Rezoning Transportation Analysis

Petition Number: 2024-022

General Location Identifier: 03703102, 03703113

Revision Log:

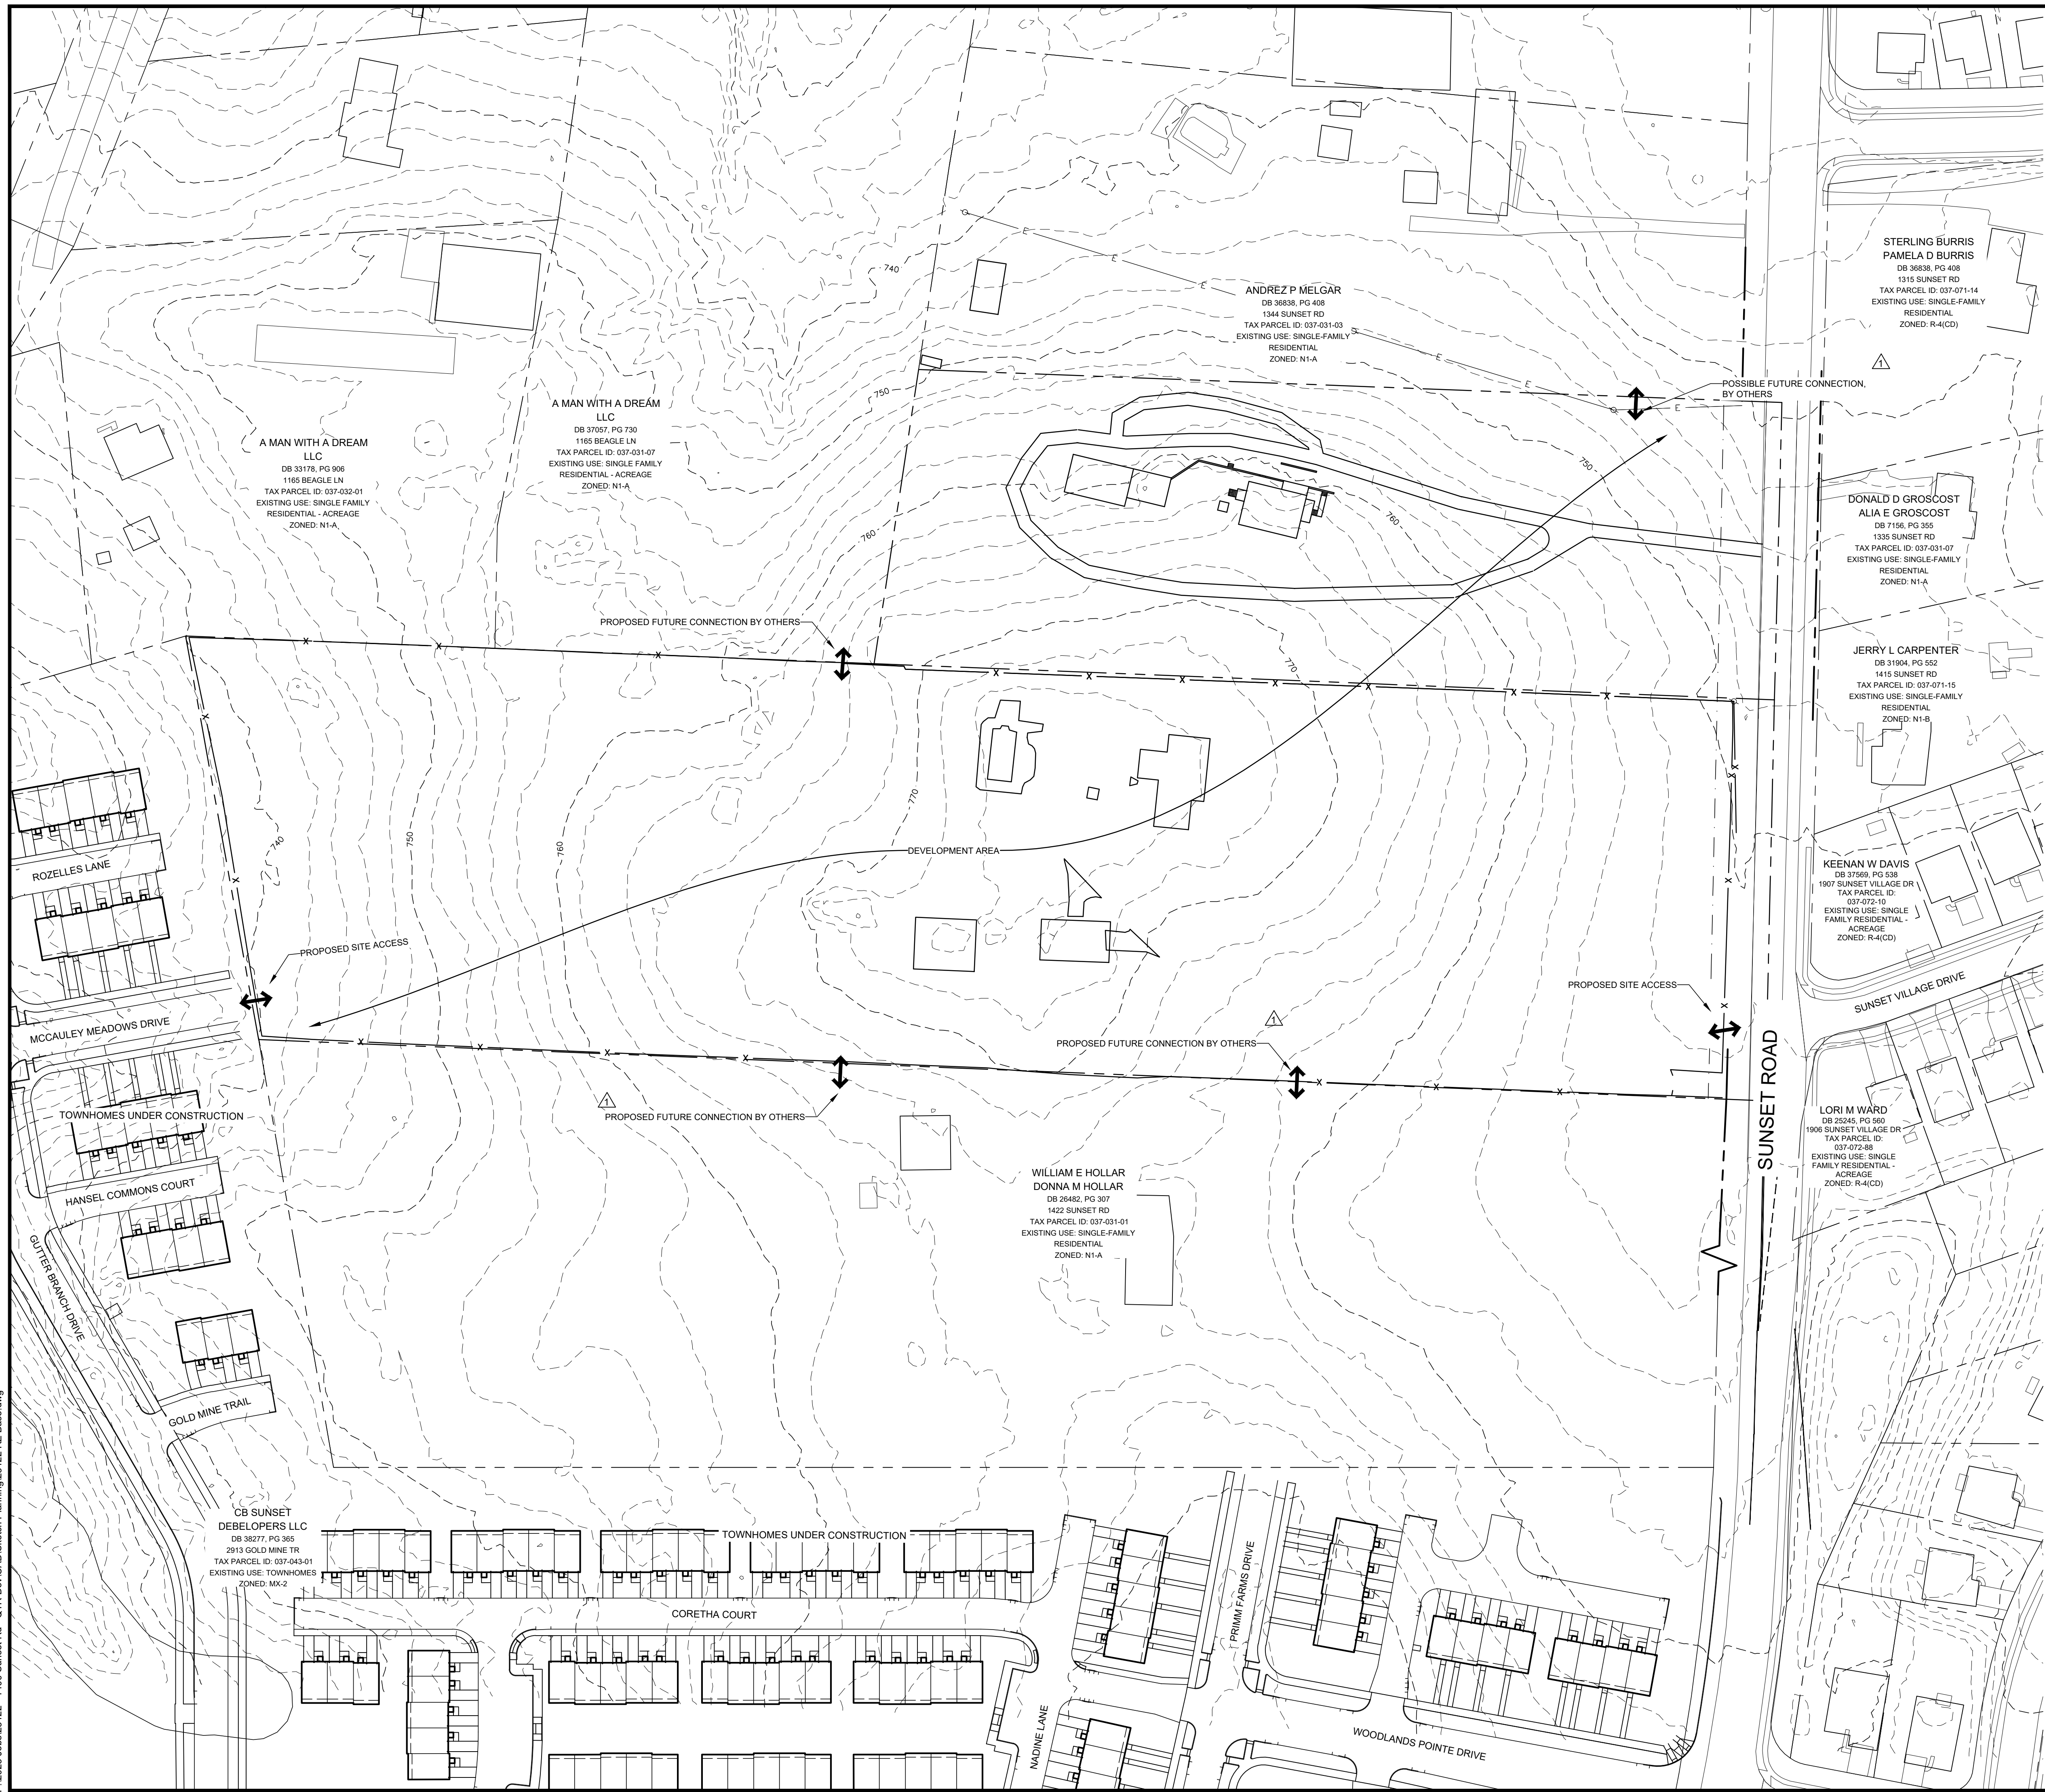
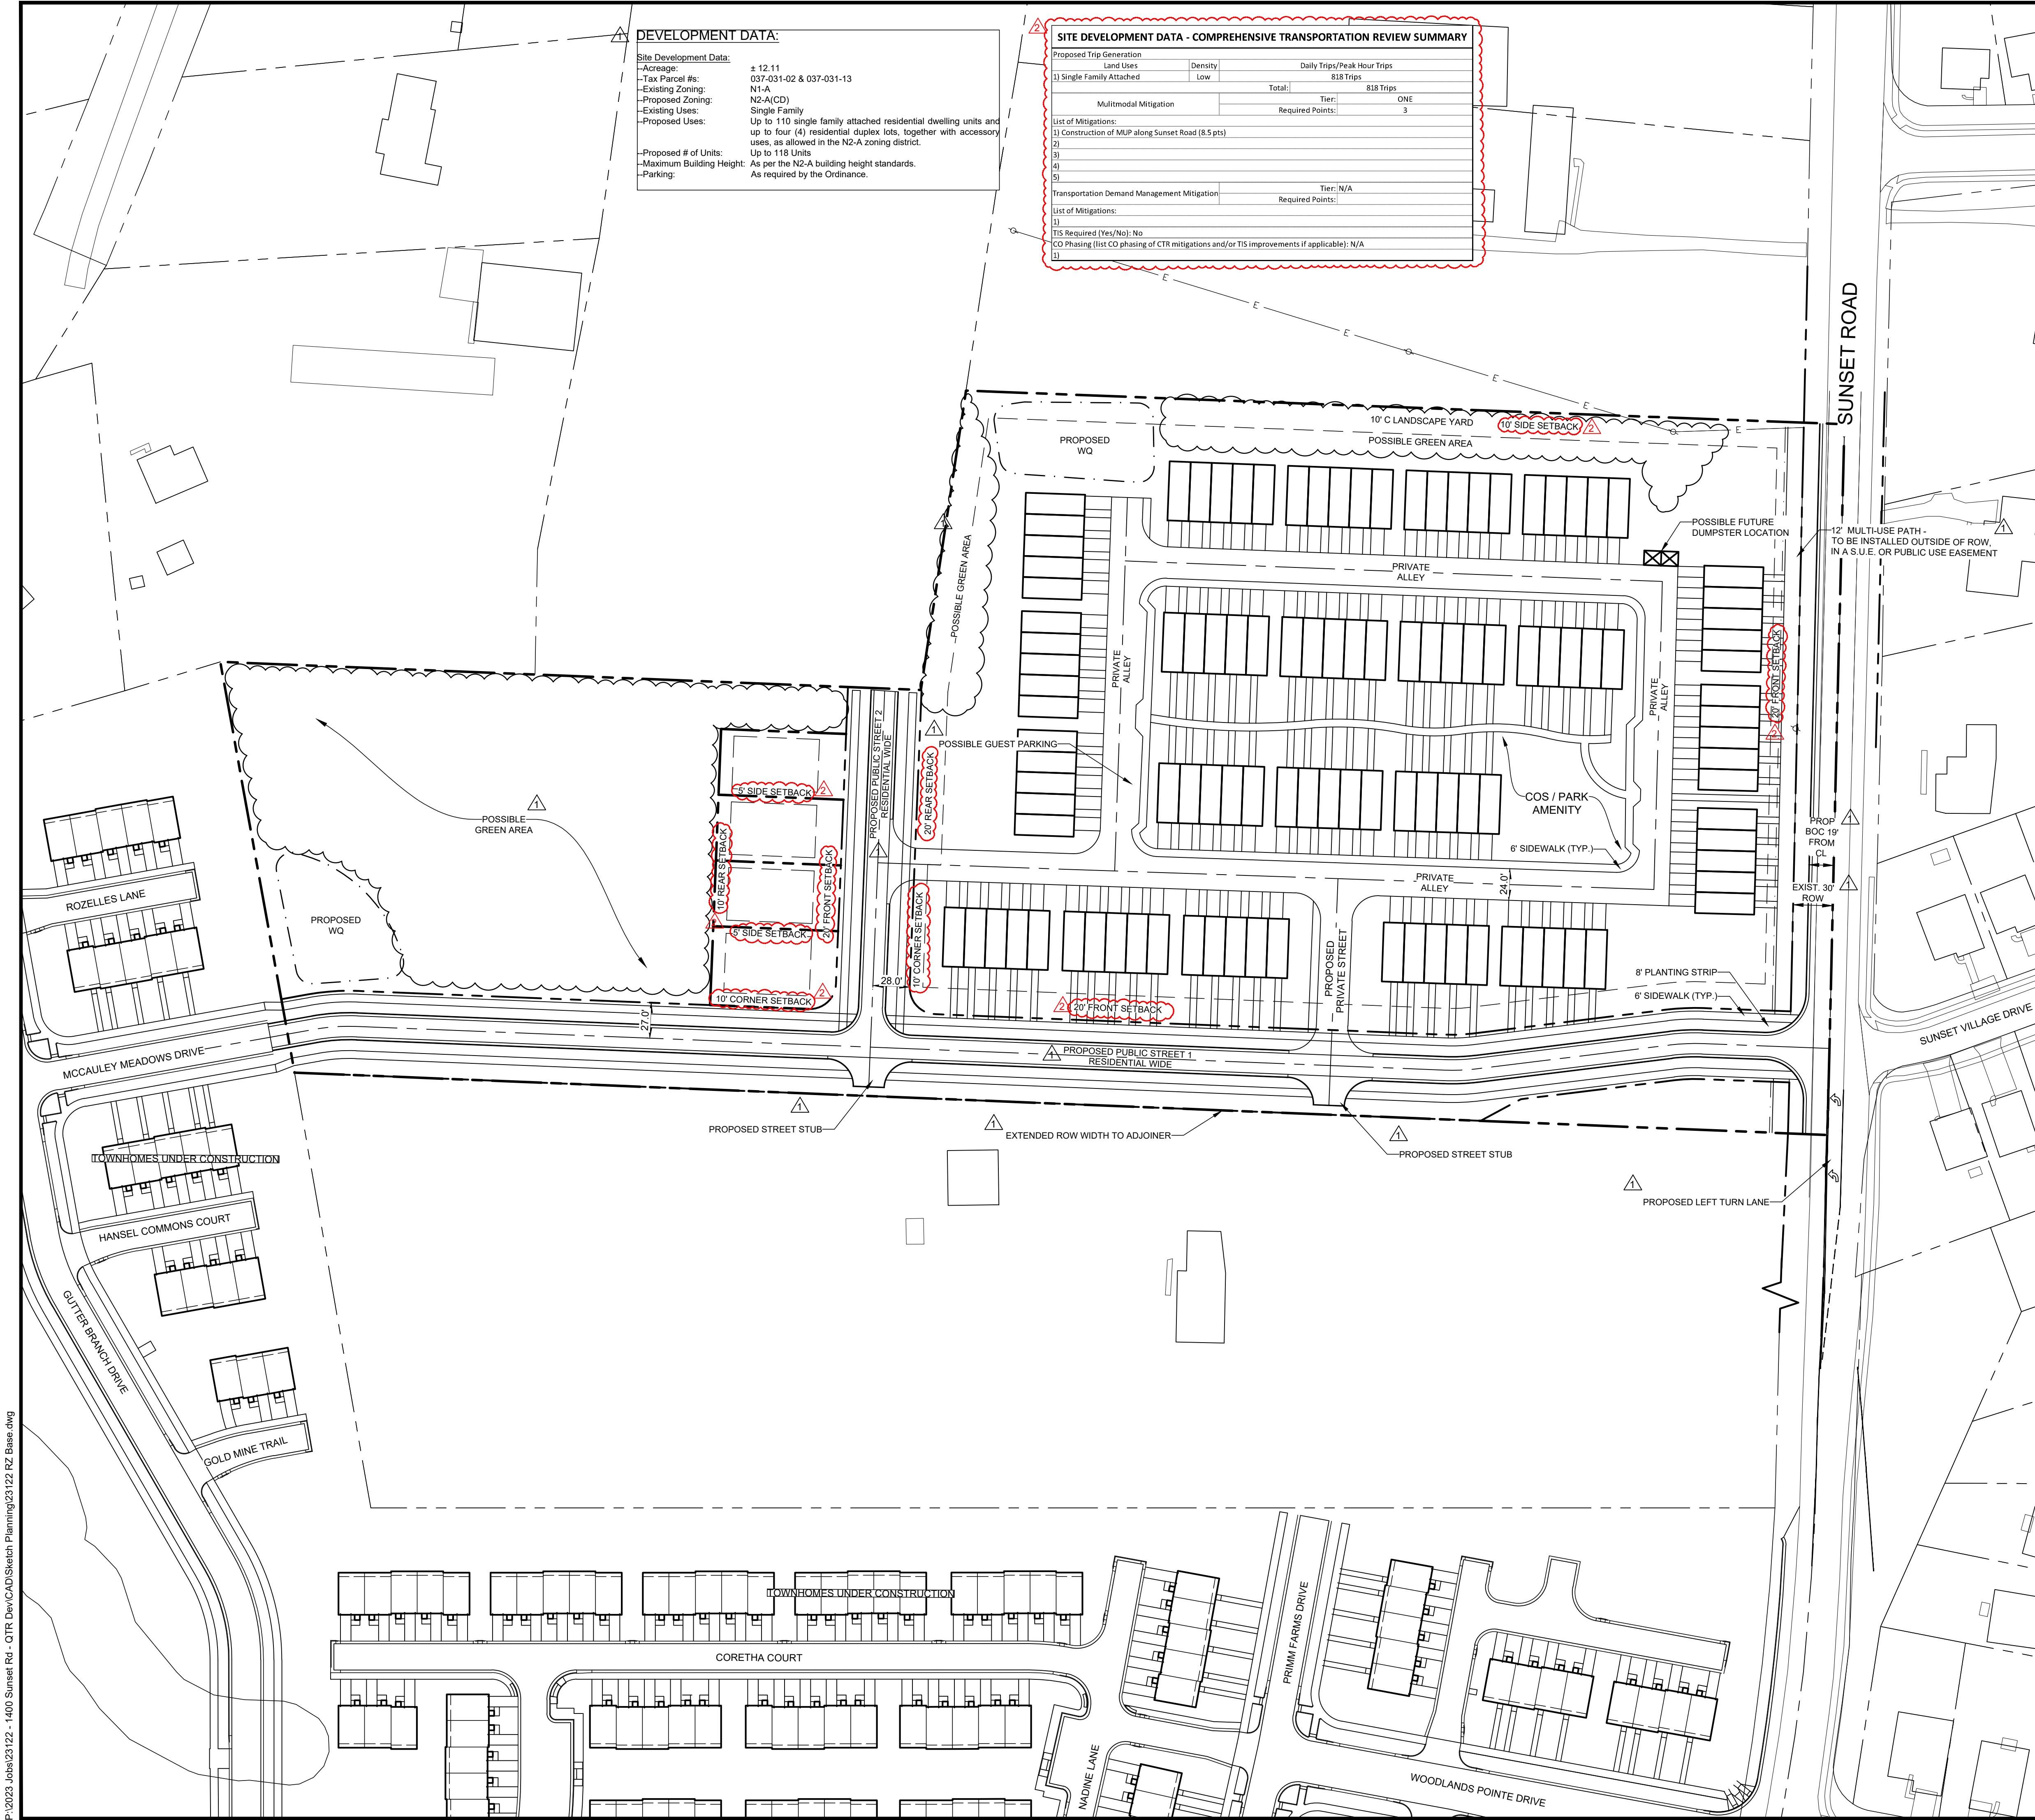
- Outstanding Comment 03-27-24:** Revise site plan and conditional note(s) to commit to creating cross-access with the Northern Parcel fronting Sunset Road per Article 31.2 in the UDO.
Outstanding Clarifying Comment: Show proposed cross access with the Northern Parcel at some location along the property line. Per UDO 33.6 the cross-access connection shall have a minimum 20 foot wide two-way paved connection.
